Your Ref: OWQC18945
Our Ref: CM/10/18/OUT
Please ask for:
Mr J Baeza

22nd June 2018

Application for Outline planning permission with some matters reserved for redevelopment of the site with 1 No. 4-bed detached bungalow, 1 No. 3-bed detached chalet bungalows & 2 No. 3-bed semi-detached bungalows & associated works.
Departure from the Development plan
Mistletoe Farm Horsemere Green Lane Climping

1071/DPA05

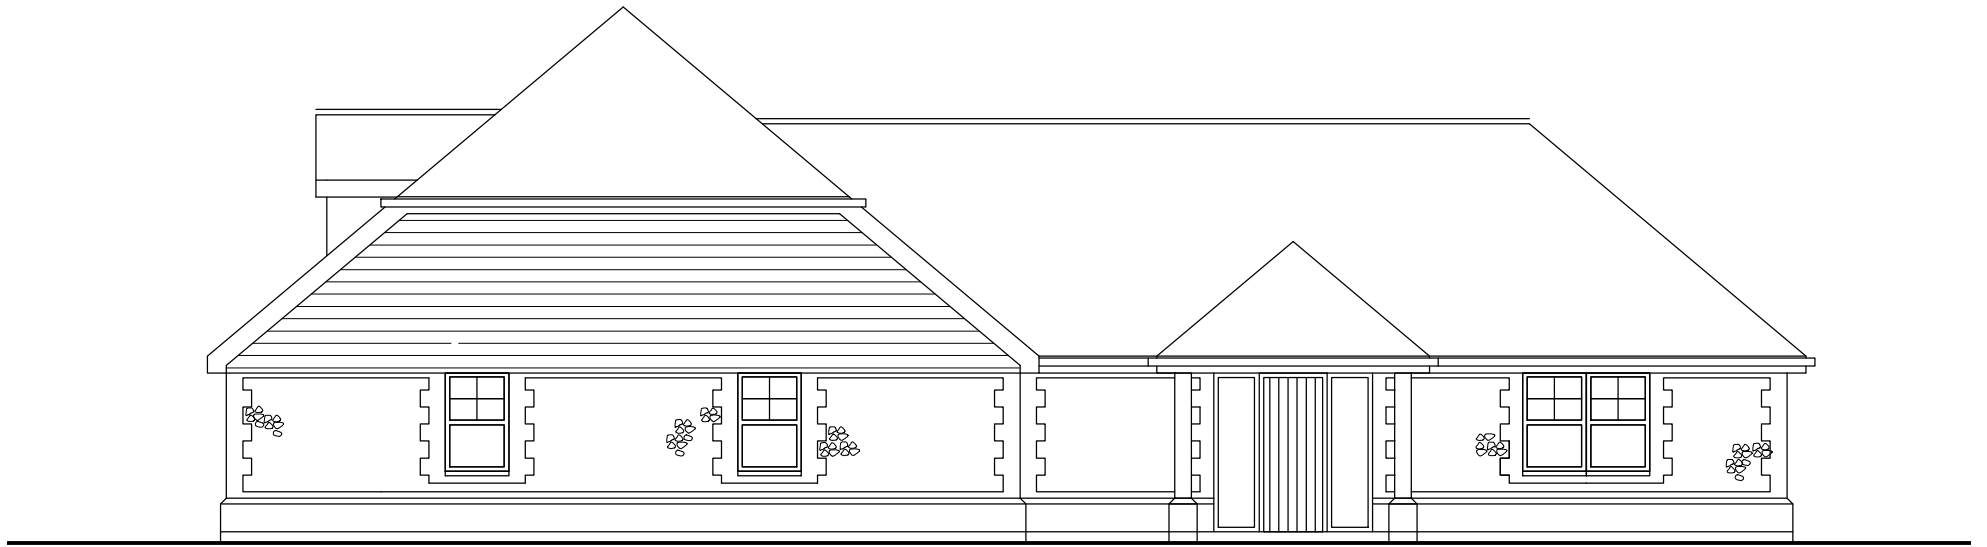
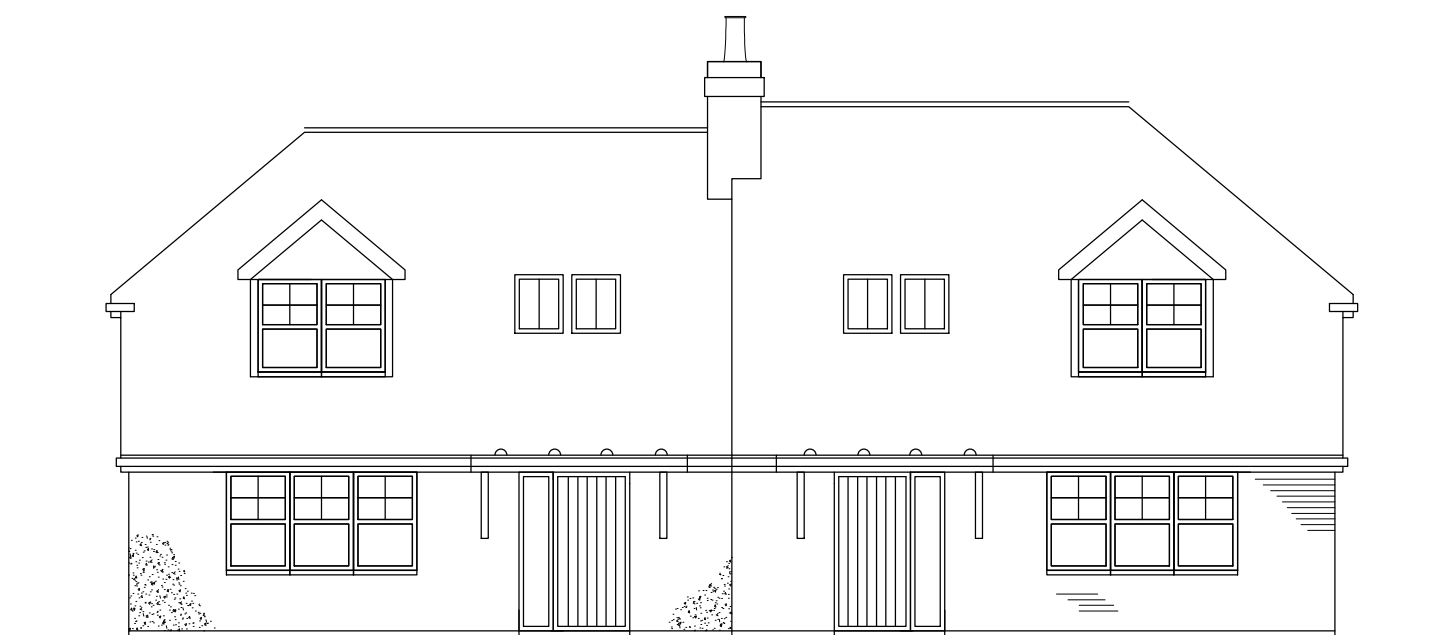
- 1. The Planning Officer is satisfied that the proposed chalet bungalows do not overlook or compromise the privacy of nearby properties, including those in Woodridge Walk*
- 2. West Sussex County Council has no highway objection to the proposed access onto Horsemere Green Lane*
